TFH ARCHITECTS 100 COMMERCIAL STREET PORTLAND MAINE 04101 TELEPHONE 207-775-6141 ARCHITECTURE AND PLANNING

July 23, 2007

RE: Bayside East, Proposed Elderly Housing, 47 Smith Street

In response to your email listing questions regarding the Bayside Permit Drawing Set see below.

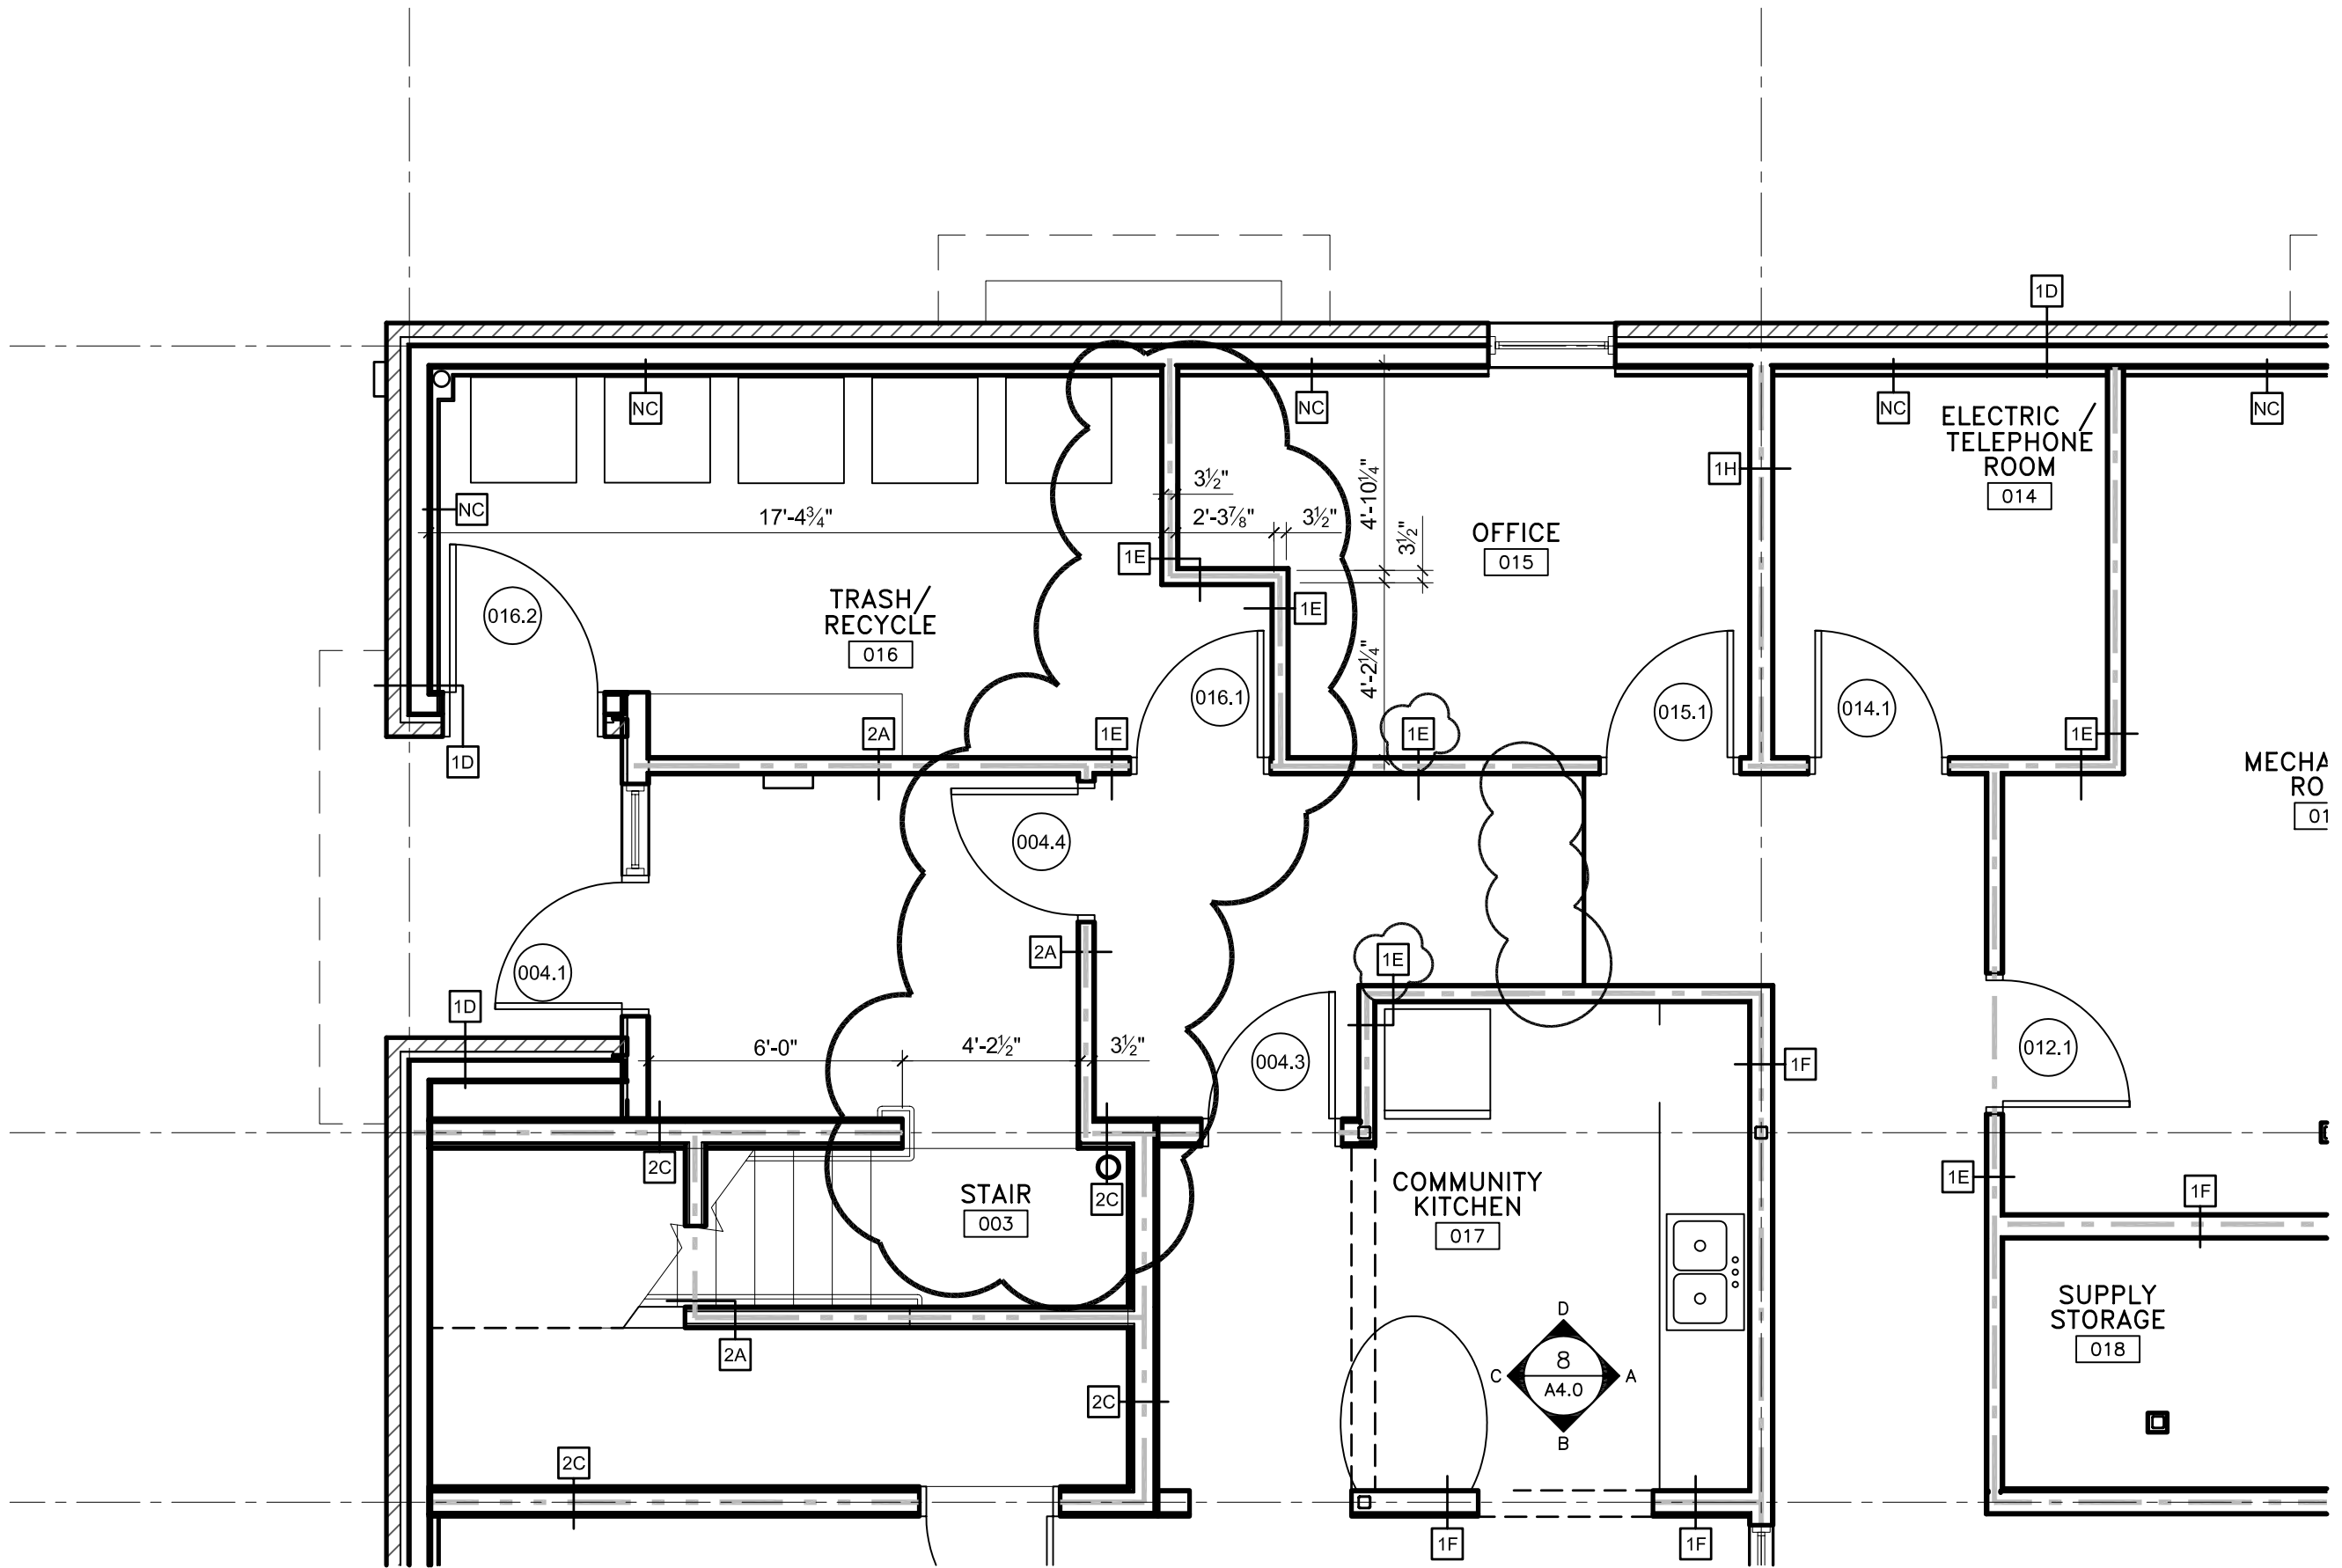
- 1.) See the attached ASK-1 and ASK-2 making the stair directly exit onto the sidewalk.
- 2.) The basement level of the building is considered a basement per the definition of a basement in IBC 2003 section, 502.1, it is not more than 6 ft above the grade plane, it is not more than 6 ft above the grade plane for more than 50% of the building, is not more than 12 ft above finished ground at any point.

A5.3

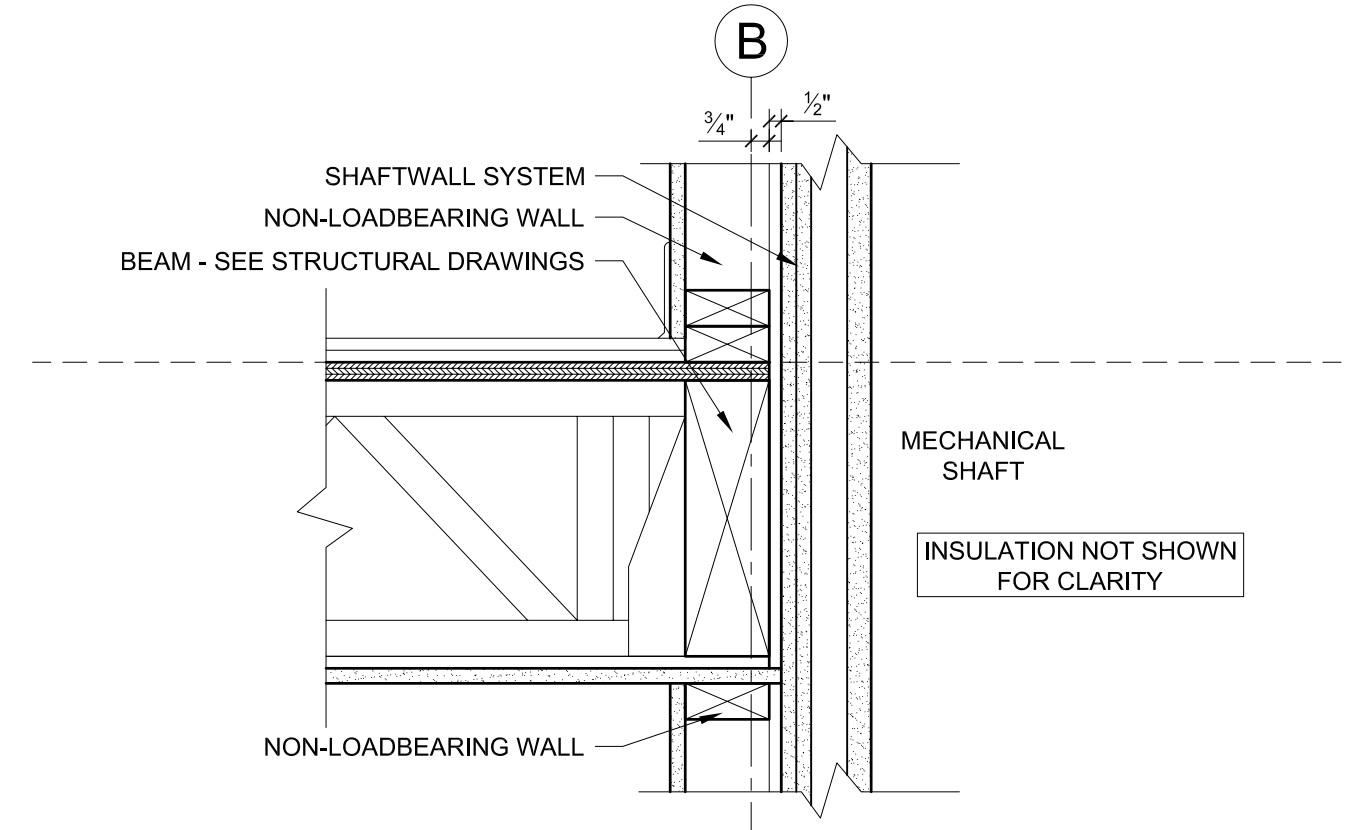
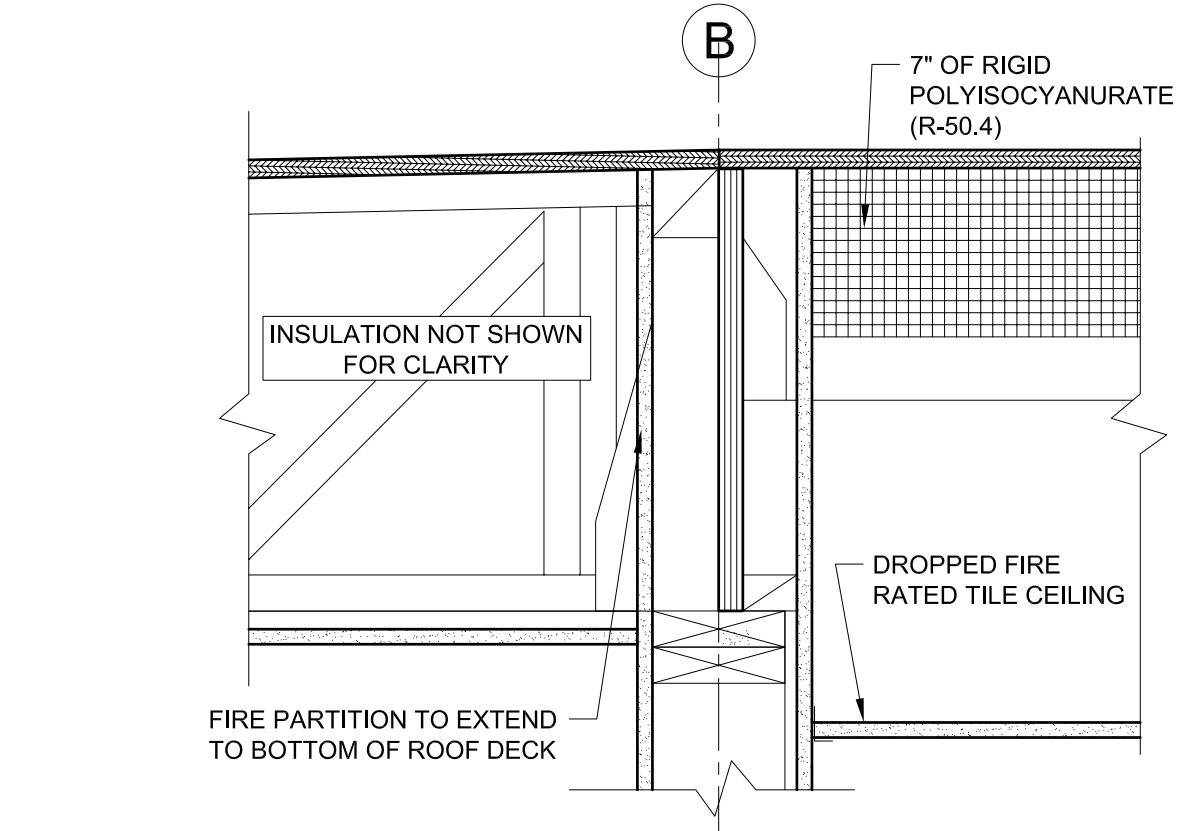
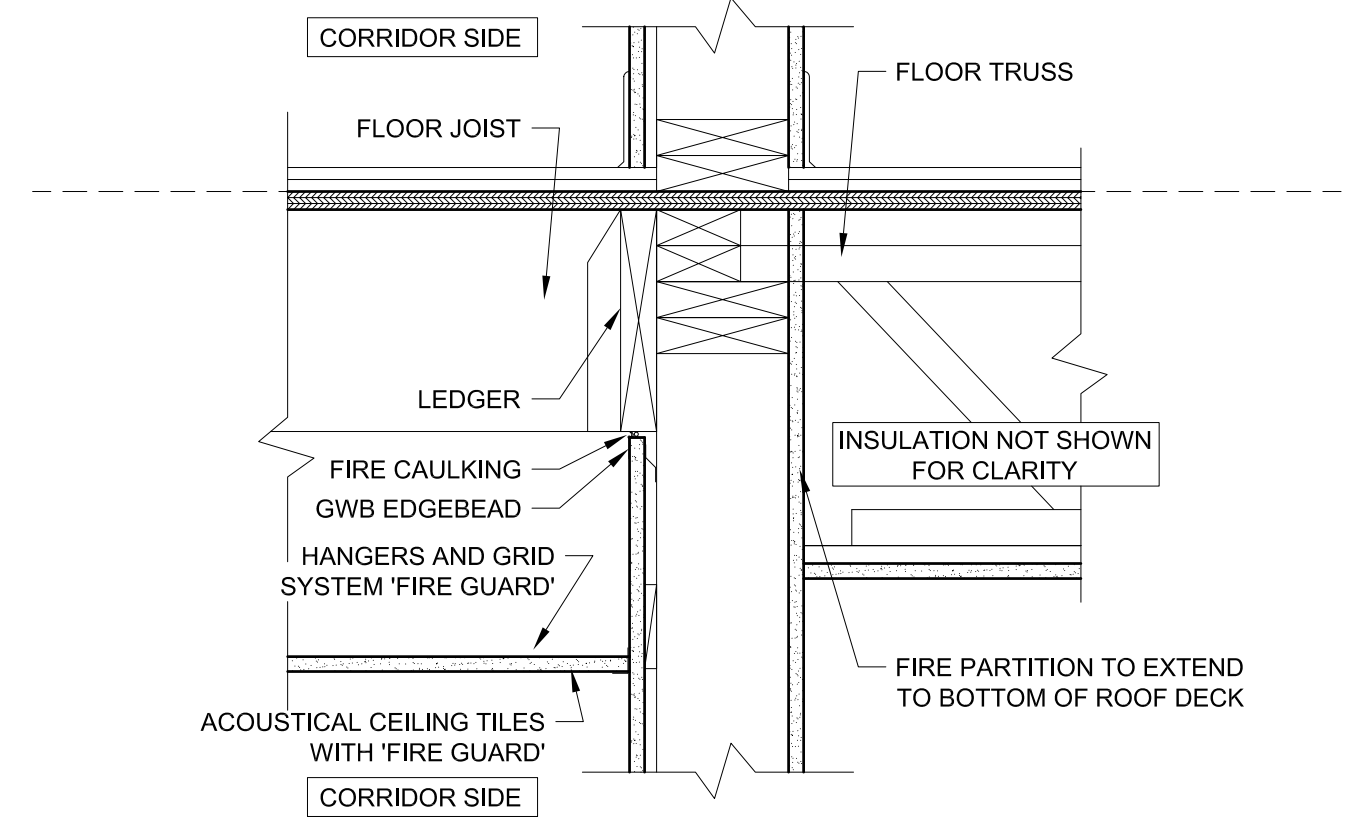
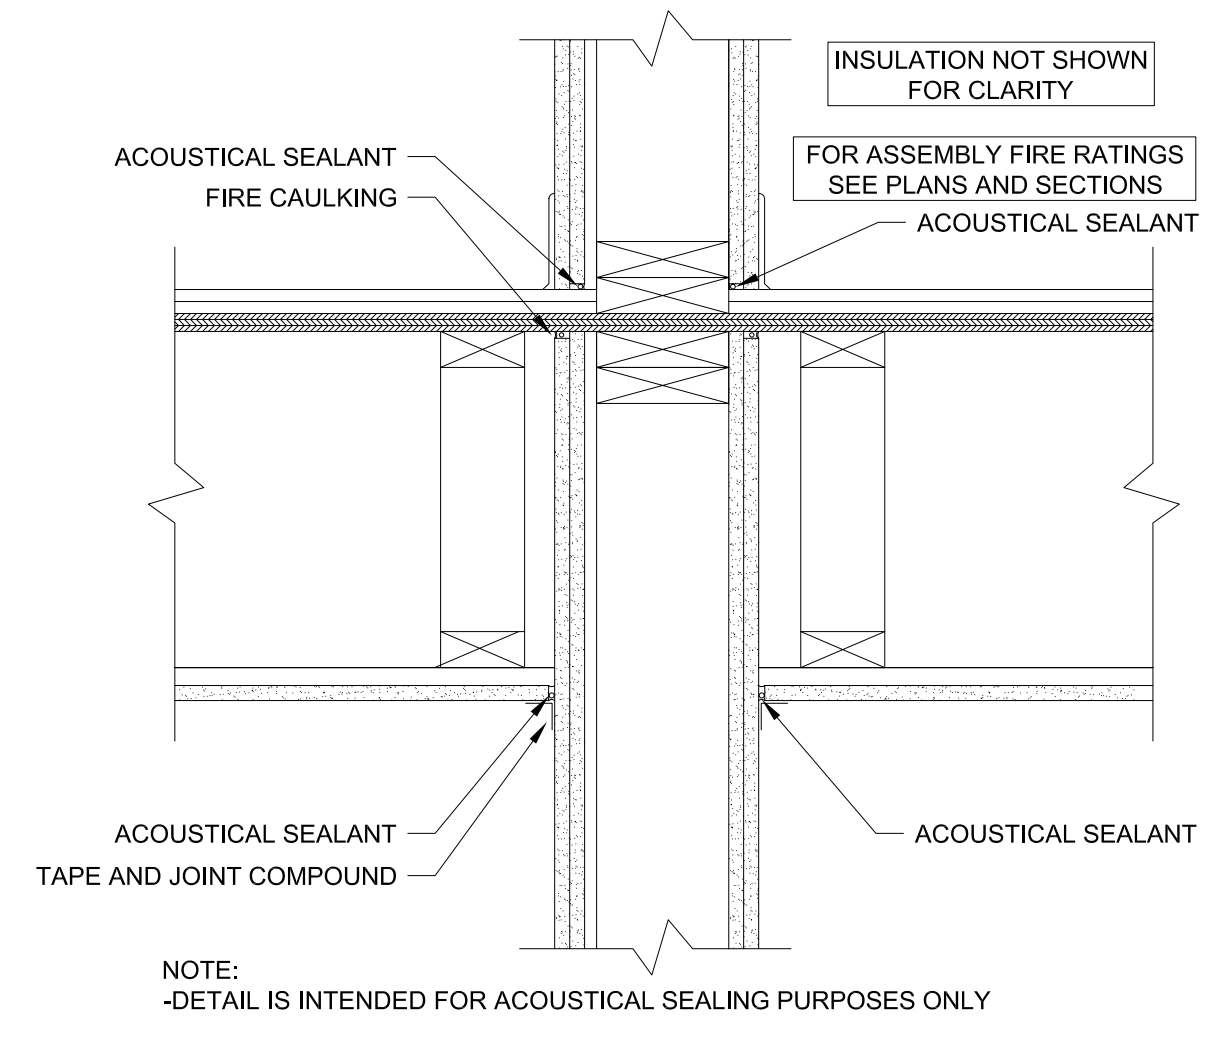
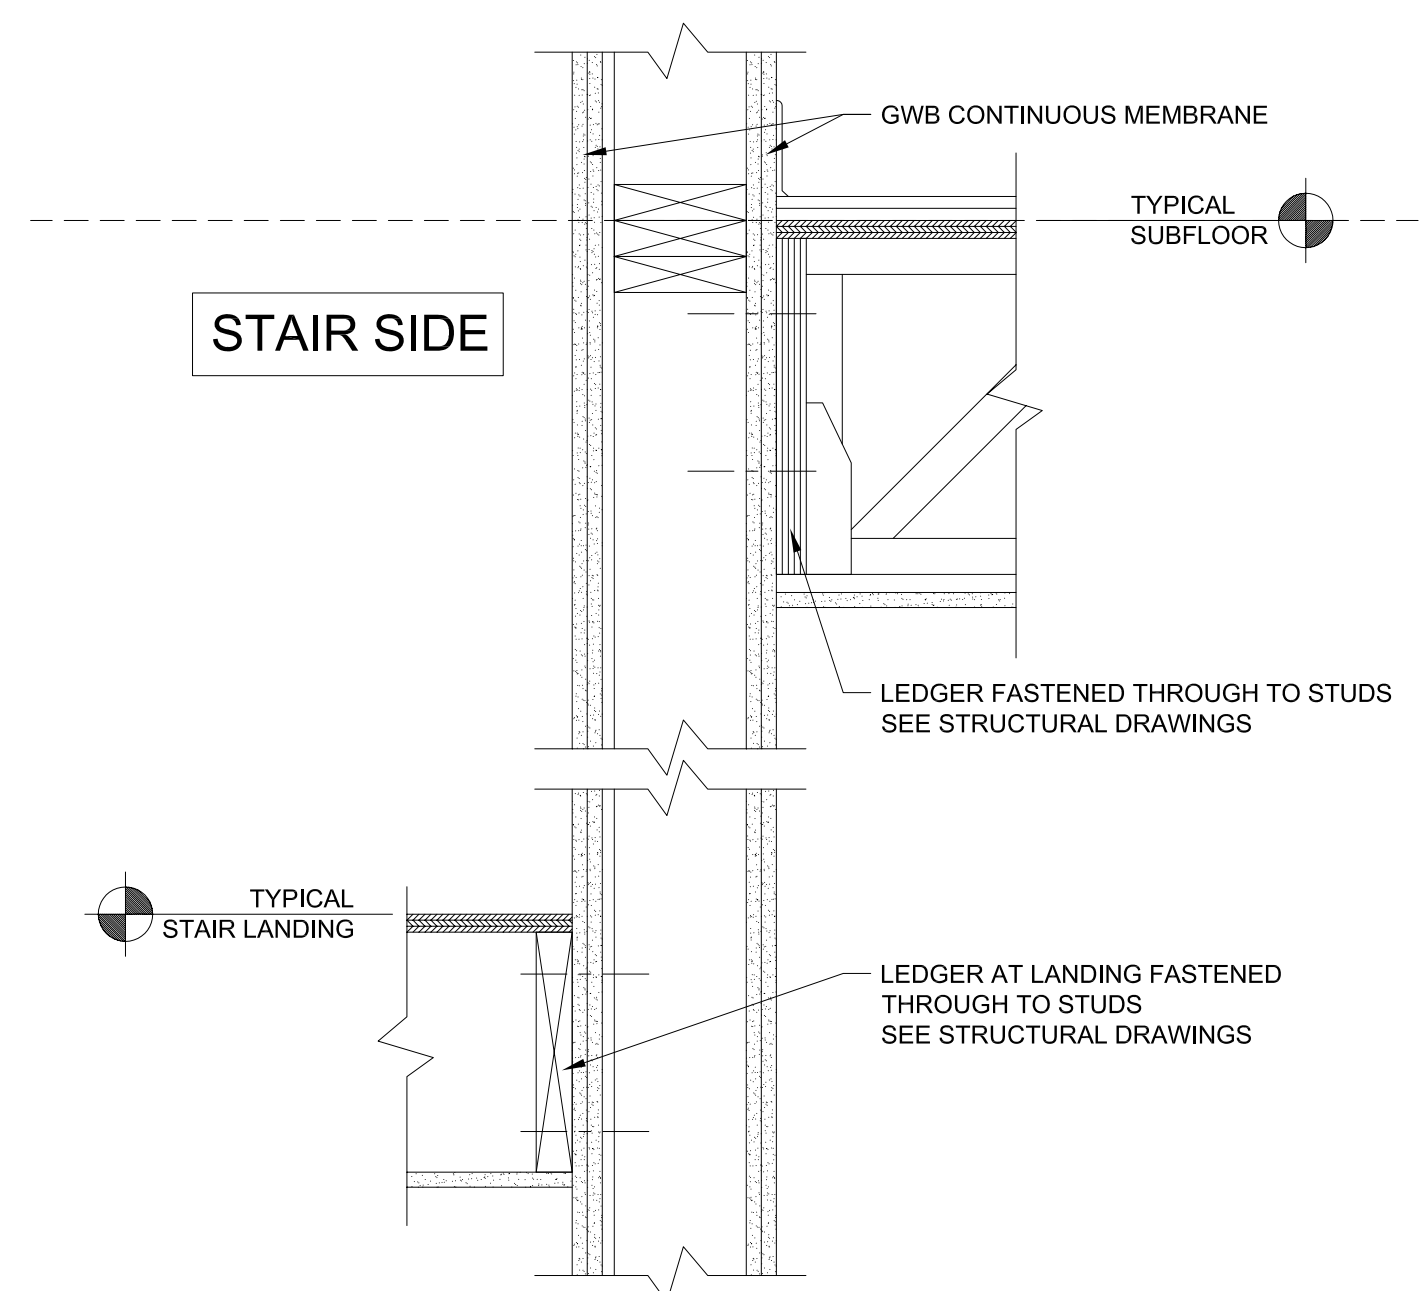
- 5.) See specification section 07841 THROUGH-PENETRATION FIRESTOP SYSTEMS along with the Wall / floor-ceiling fire barrier details on Sheet A5.3
- 6.) We are under IBC 2003 for this project so we have designed to IBC 2003 code and window opening standards.
